Our Case Number: ABP-314942-22

Re: BusConnects Lucan to City Centre Core Bus Corridor Scheme
Lucan to Dublin City Centre

Final Comments to An Bord Pleanála

BusConnects6 Lucan to City Centre Bus Scheme

C:\users\costello\appdata\local\projectwise\work\mott-gb-pw-03\0229778\BCIDA-ACM-STR_GA-0006_BR_03-DR-CB-0101.dwg

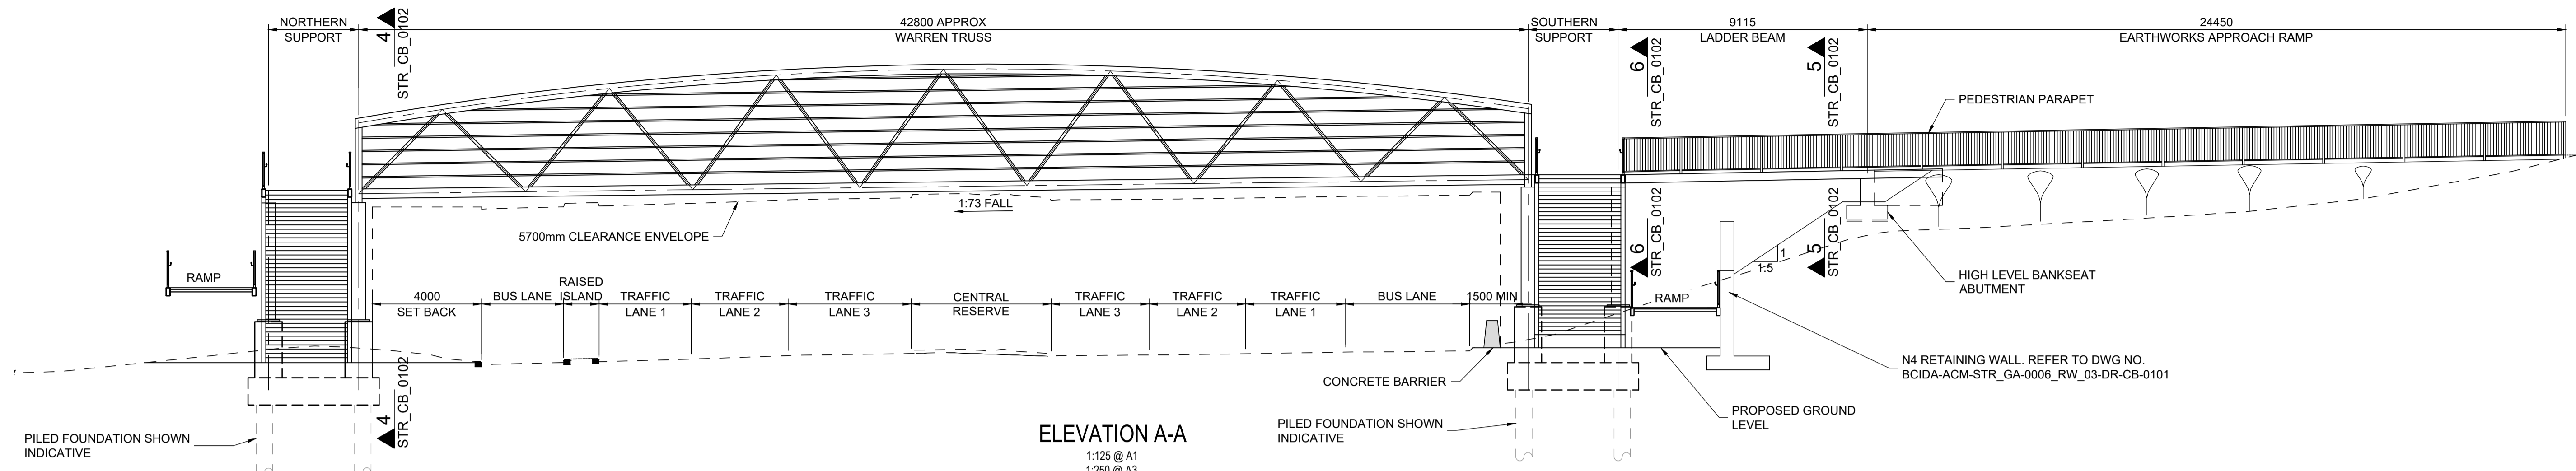
Subsequent scrutiny of a drawing¹³ for Chapelizod Hill Road shows that there are no retaining barriers between the outside bus lane at the station and the two car lanes adjacent to it. These car lanes handle 65,000 – 85,000 vehicles per day at speeds of up to 80 kph. The State would be liable if it exposed careless or confused passengers to such dangers.

CRA would ask ABP to dismiss the applicant's request for permission for a bus station on the Bypass, as it is impossible to guarantee the safety of passengers from such an unguarded and unguardable platform.

Some changes appear to have been made to the proposed scheme at Chapelizod Hill Road in an attempt to mitigate overshadowing.¹⁶ The original parapet was c. 3.0m. tall and it is being replaced with a 1.25m. tall concrete parapet (topped with a 550mm. mesh infill fence). As against that, the new parapet is 6.4m. ¹⁷closer than before to the gardens below in Chapelizod Court, Chapelizod Hill Road and Knockmaree apartments. An overshadowing exercise should be carried out to determine the net effect of these changes

¹⁷ i.e. summing parapet width (1.25m.) to footpath (2.0m.) to bus lane (3.3m.) to trief kerb (0.6m). The proposed 1.25m. parapet looks a trifle low to intercept a crashing vehicle coming across the Bypass at speed, since the "new trief kerb" will probably tilt it upward slightly, It would then crash into the gardens below. Because of its heft and height, there was never any doubt that the old parapet could intercept a skidding, crashing vehicle.
